Rezoning Transportation Analysis
Petition Number: Insert Zoning Petition #2021-025
General Location Identifier: Tax ID 16511318

Revision Log:	Date	Description
	02-25-21	First Review (LJ)
	03-25-21	Second Review (WB)
	04-16-21	Third Review (KP)
	05-27-21	Fourth Review (WB)

Transportation Summary

RZ-1.0

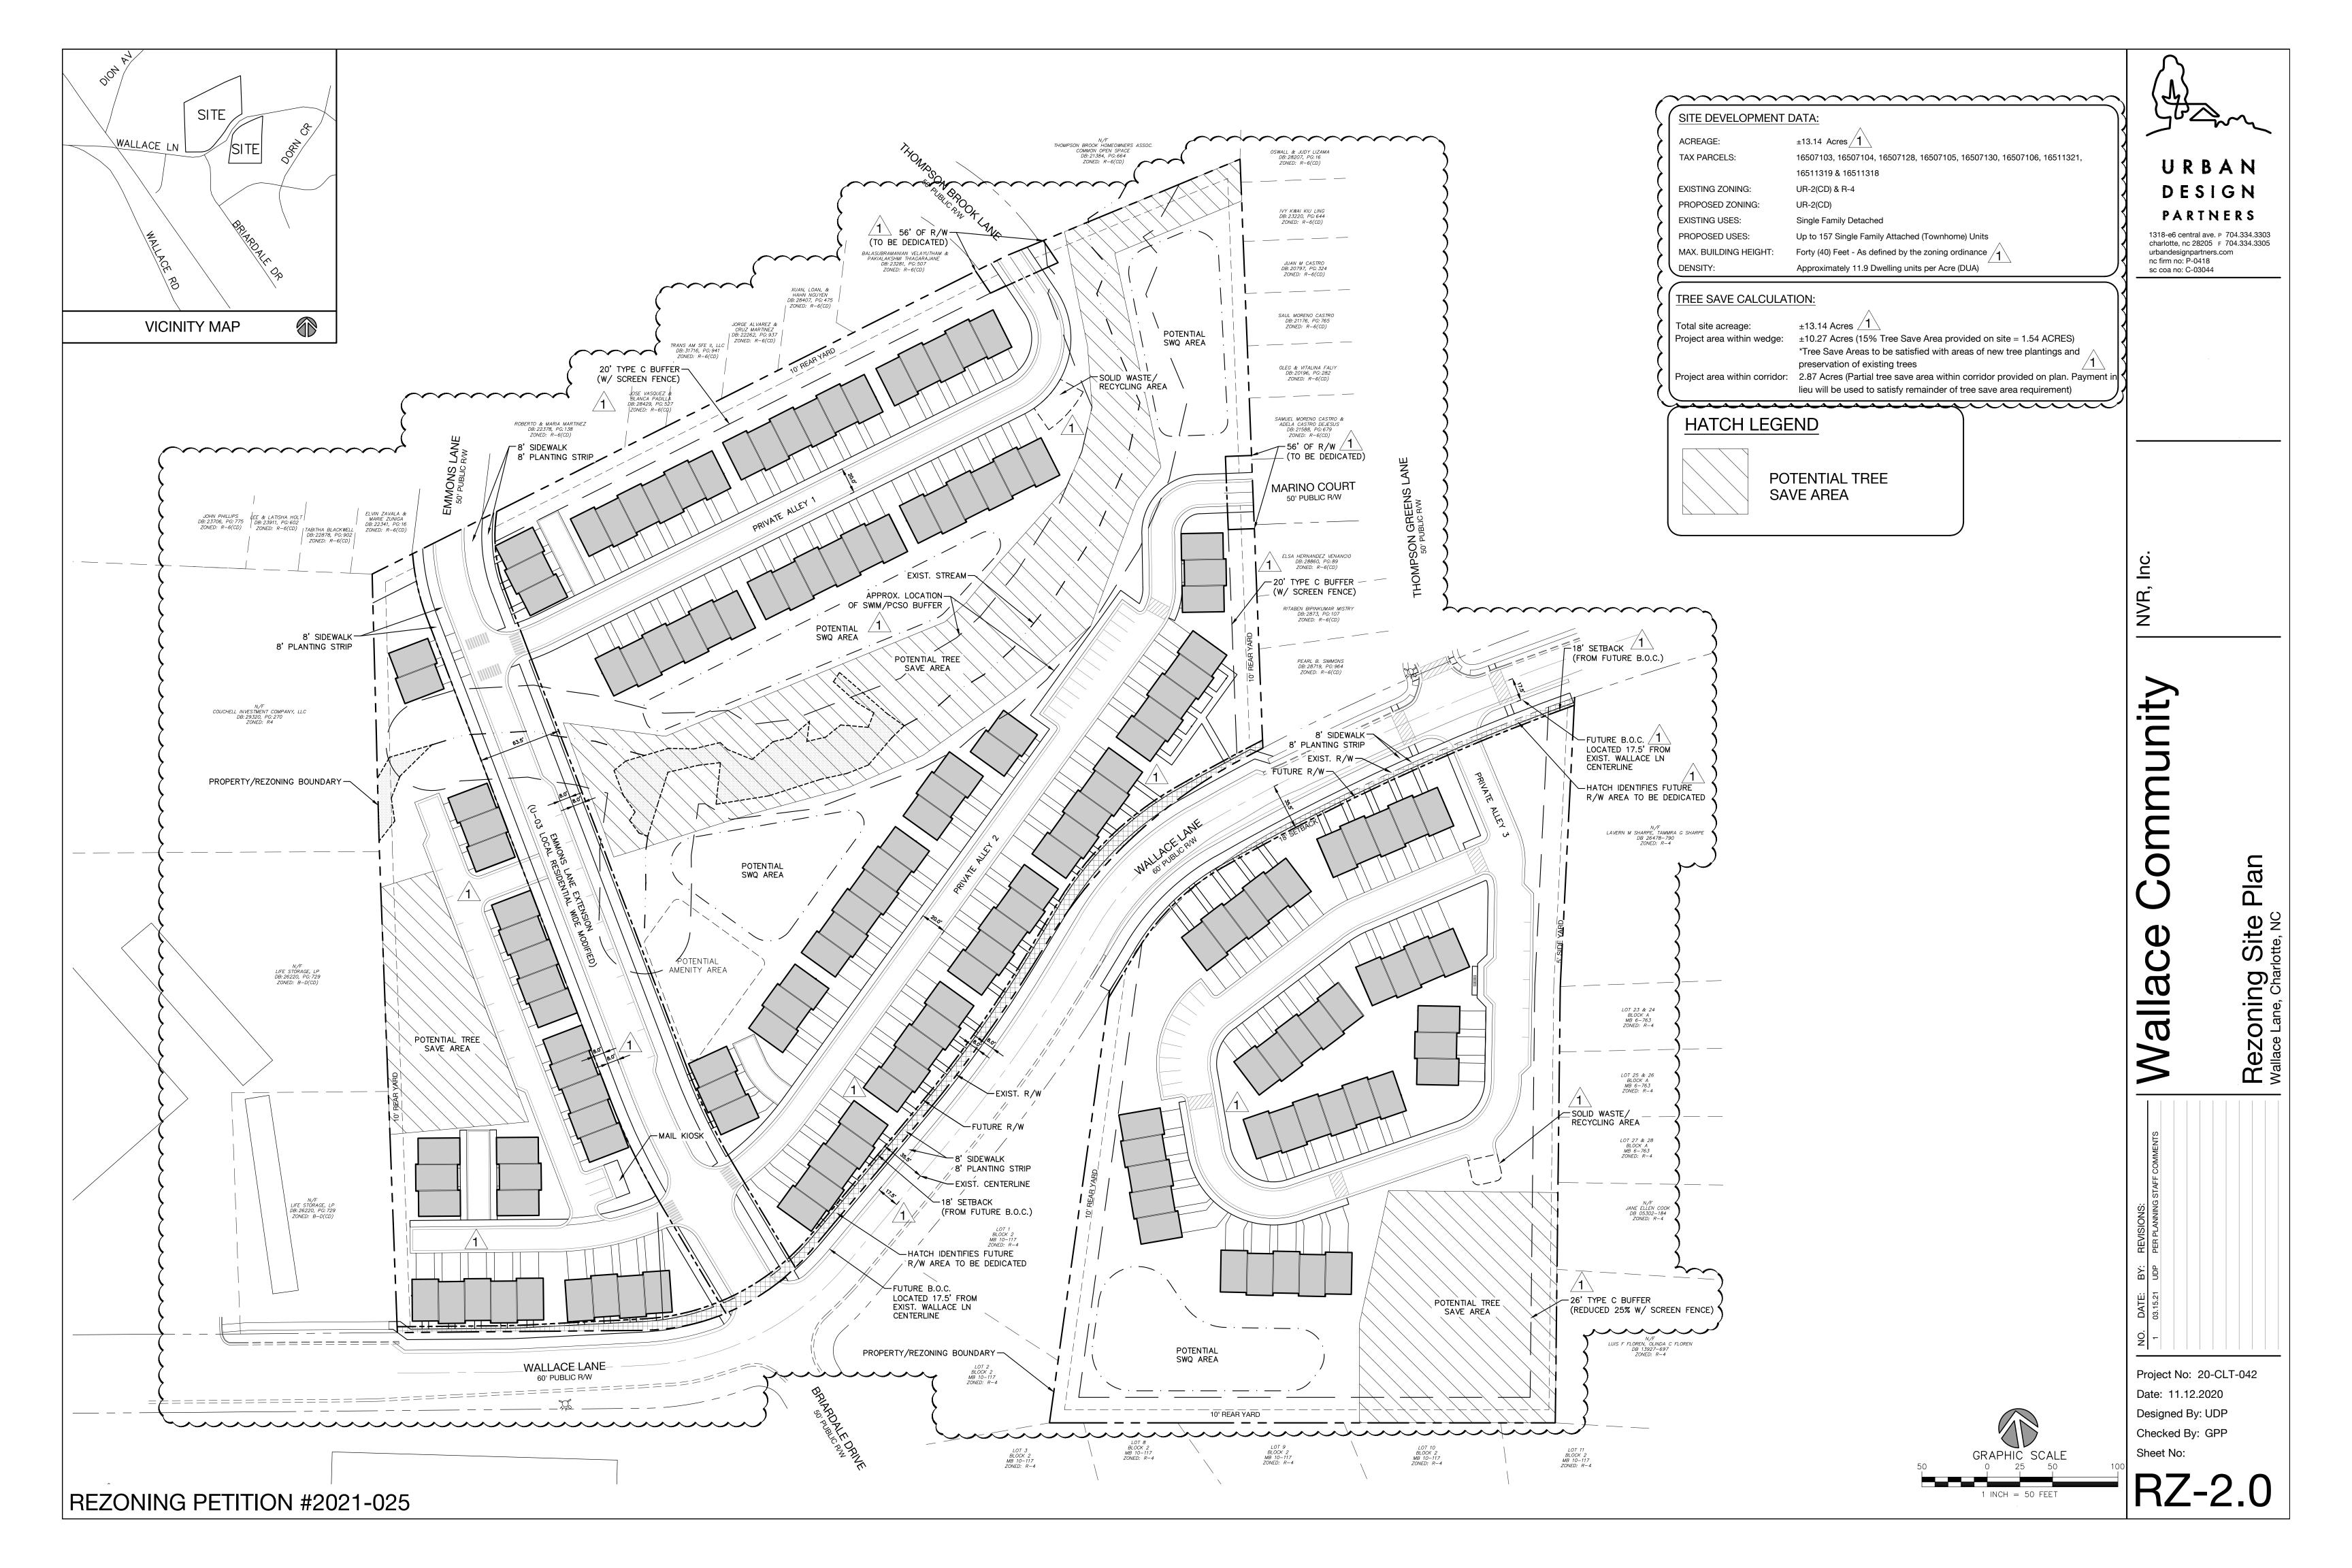
4. **OUTSTANDING (03/18/2021):** ~~Revise site plan and conditional note(s) to commit to construct an 8-foot planting strip, and 8-foot sidewalk on Wallace Lane and Emmon Lane extension per Chapter 19 / Chapter 20. The site plan shall label and dimension both items from the back of curb and gutter and road centerline. CDOT request of rights-of-way set at 2' behind back of sidewalk where feasible.~~

5. ~~**OUTSTANDING (03/18/2021):** Revise site plan to provide for Private Alley 1 and Private Alley 2 to be private streets, as opposed to alleys, to allow for better connection to the existing public road street stubs~~

7. **New Comment (03/25/2021):** Revise site plan and conditional note(s) to commit to constructing left turn lanes into the development per CDOT standards for developments that generate more than 500 trips a day.
~~**Update to Comment as a Result of the 04-12-2021 Site Plan:** Revise the site plan and conditional notes by committing to constructing a westbound left turn lane, on Wallace Lane, onto Briardale Drive. This will provide a more fluid full movement intersection.~~

8. **New Comment (03/25/2021):** Revise site plan to demonstrate adequate Intersection Sight Distance (ISD) at all proposed public street connections to existing Wallace Lane per CDOT Sight Distance Policy and to ensure safe ingress and egress into the development. ISD must be shown in both horizontal and vertical dimensions (plan/profile) along the sight line, not the roadway centerline.
~~**Update to Comment as a Result of the 04-12-2021 Site Plan:** Revise the ISD Profile for Emmons Lane Extension and Wallace Lane to depict Stopping Sight Distance Profiles in addition to Intersection Sight Distance Profiles. Additionally, revise the ISD Profile for Private Alley 3 and Wallace Lane to show the left turn sight line profile.~~
Update to Comment as a Result of the 05-18-2021 Site Plan: Realign the ROW along the sight line or provide an easement to protect the sight triangle by adding a note stating that "No object that impedes sight distance between a height of 30 and 72 inches above the ground surface, subject to the exceptions established in Section III of the Charlotte Sight Distance Policy, shall be located within any of these three sight triangles."
